# KITTITAS COUNTY

### MEMORANDUM

TO: All Staff  
FROM: Justin Turnbull, County Surveyor   
DATE: May 30, 2017  
SUBJECT: County Survey Review of Boundary Line Adjustment BLA-17-00005

DWN BY DLP	DATE 2/2014	JOB NO. 131201
CHKD BY GW	SCALE 1" = 100'	SHEET 1 OF 3

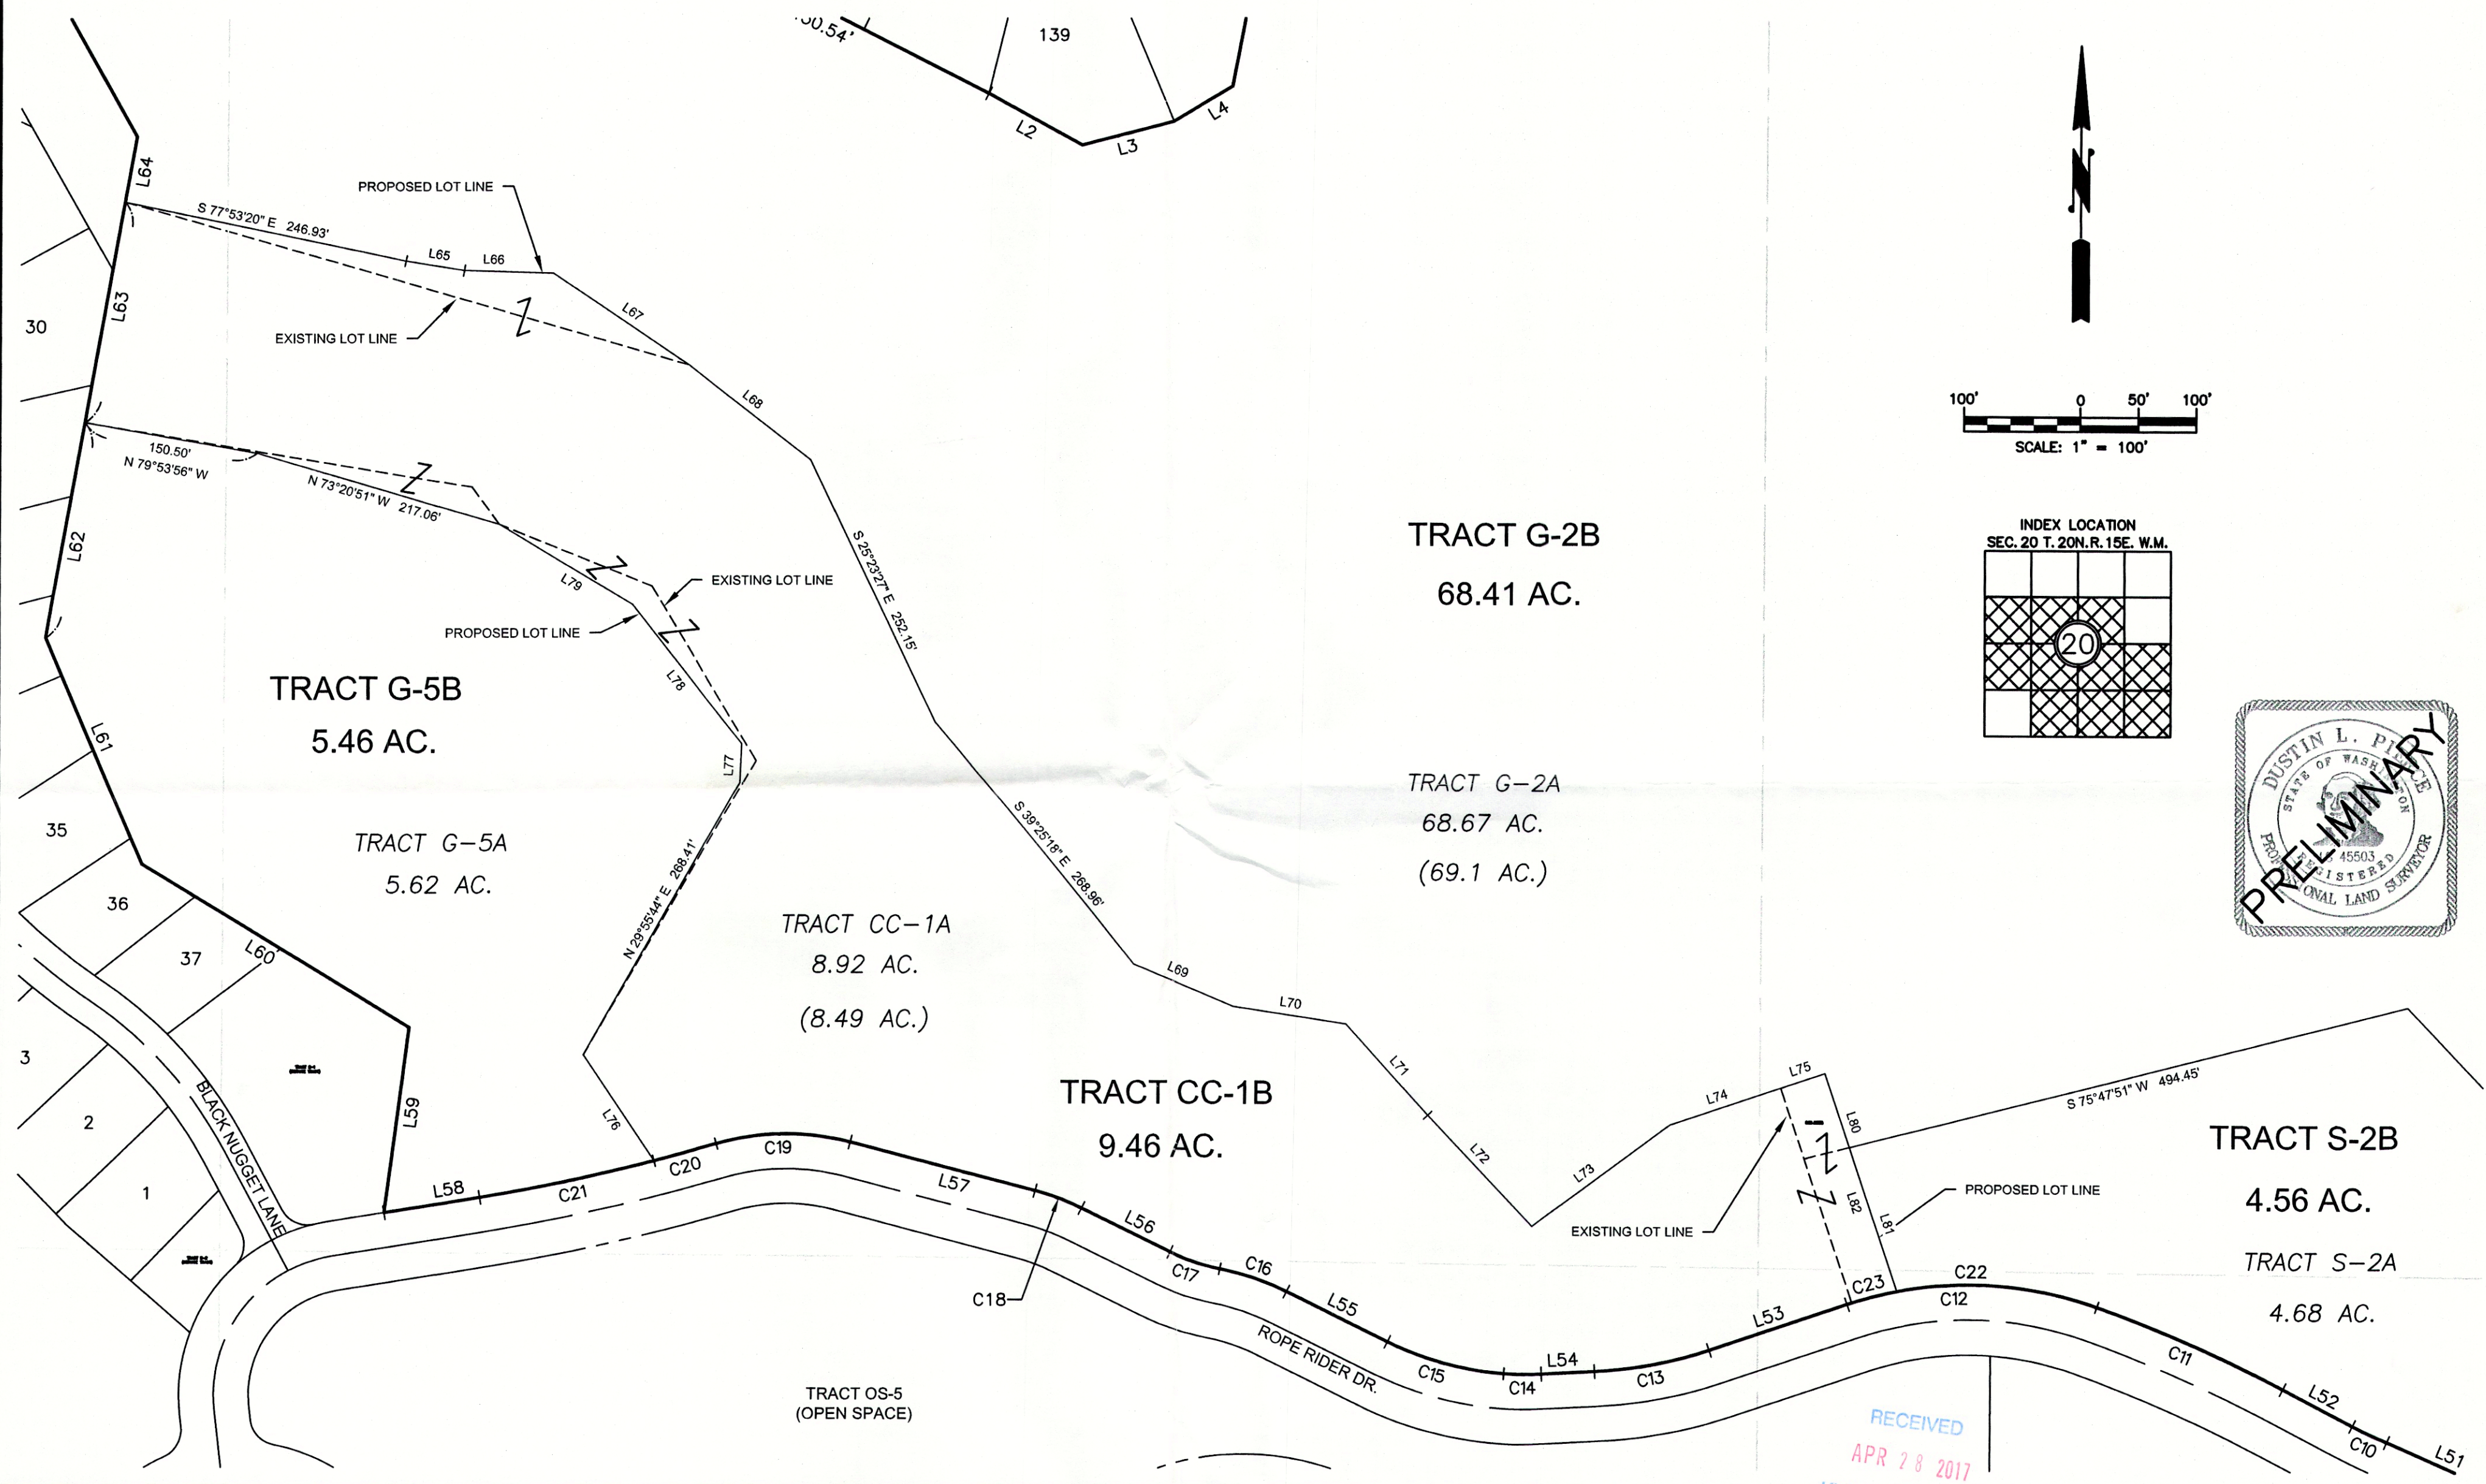
2. Sheet 1 shows some trimmed text at the top of the page, and text less than 0.08" in height near the lower left corner.
3. Roadways should be shown with name, width, ownership, Easement or R/W and surfacing (EX: Brown Rd – 60' Wide County R/W – Paved)

4. I believe the date on sheet 1 to be incorrect.
5. Basis of Bearing should be noted or stated.
6. Survey procedures statement should be shown.
7. Purpose of survey statement should be shown.

DWN BY	DATE	JOB NO.
DLP	2/2017	131201
CHKD BY	SCALE	SHEET
GW	1" = 200'	2 OF 3

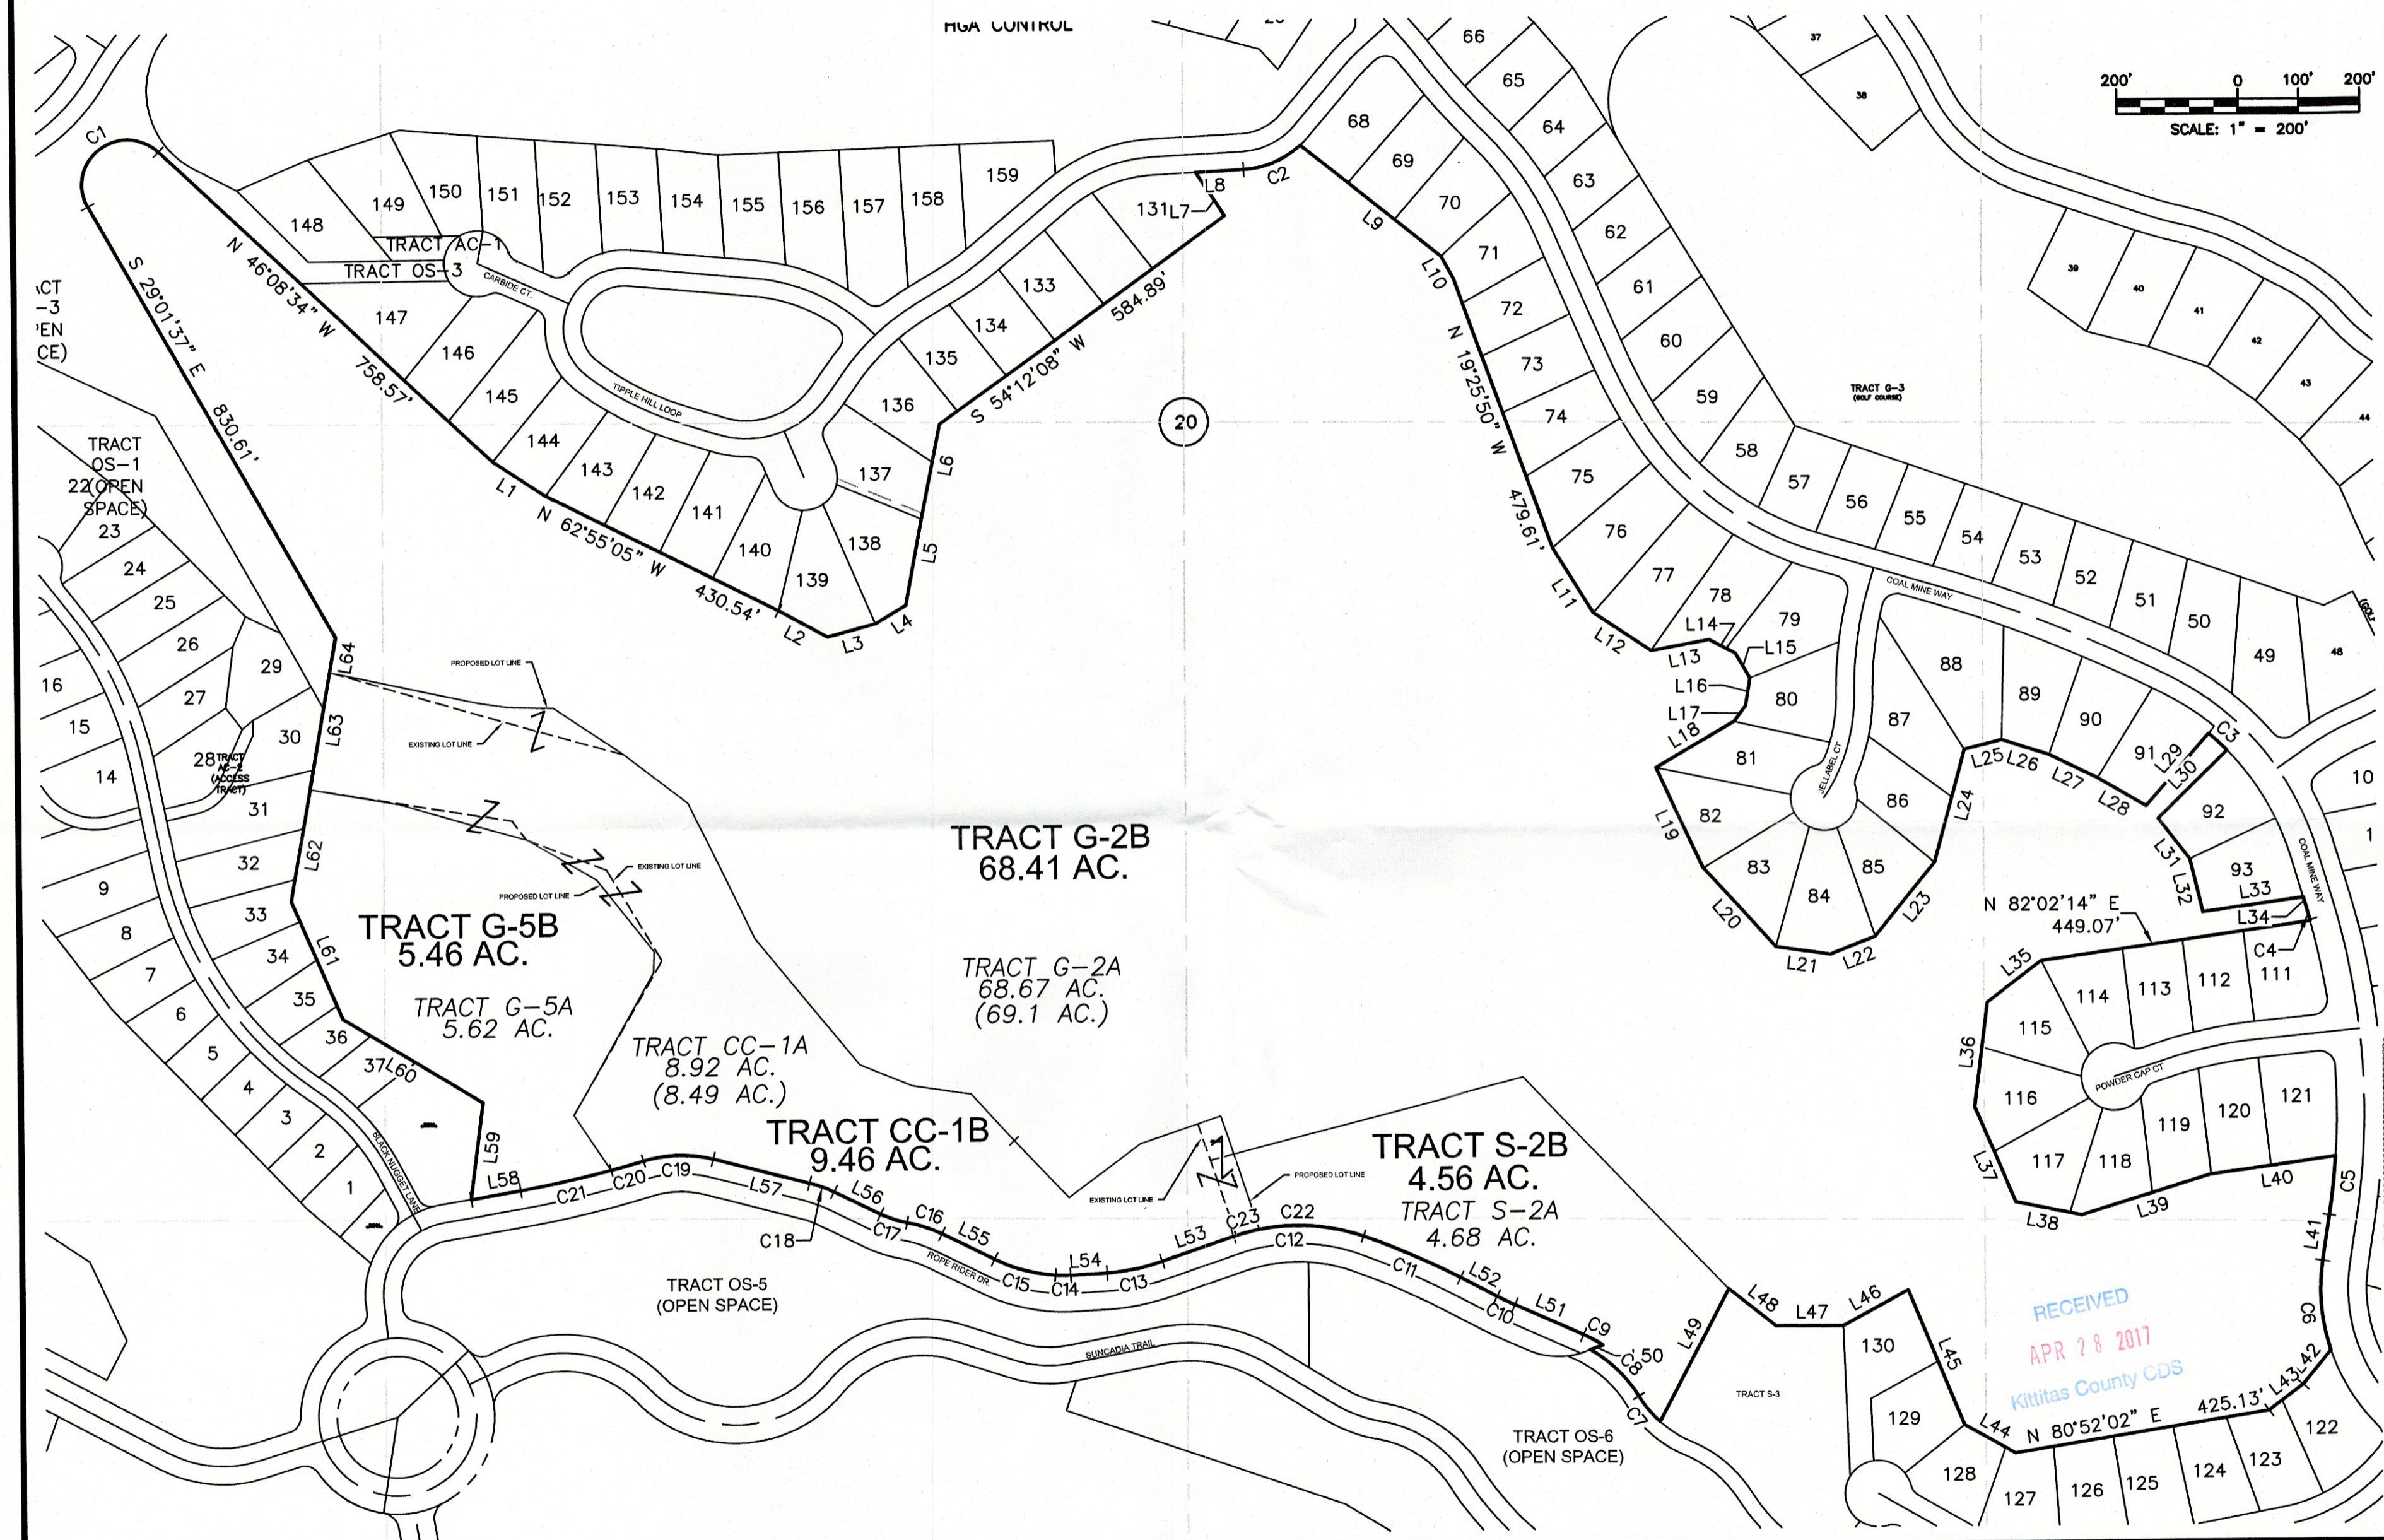
8. Controlling corners or monumentation should be shown or noted.
9. Sheet 2 shows multiple instances in road names, ex lot line labels and tract labels that do not meet 0.08" minimum text size. Additionally, there is some text trimmed near the top and left side of the page.
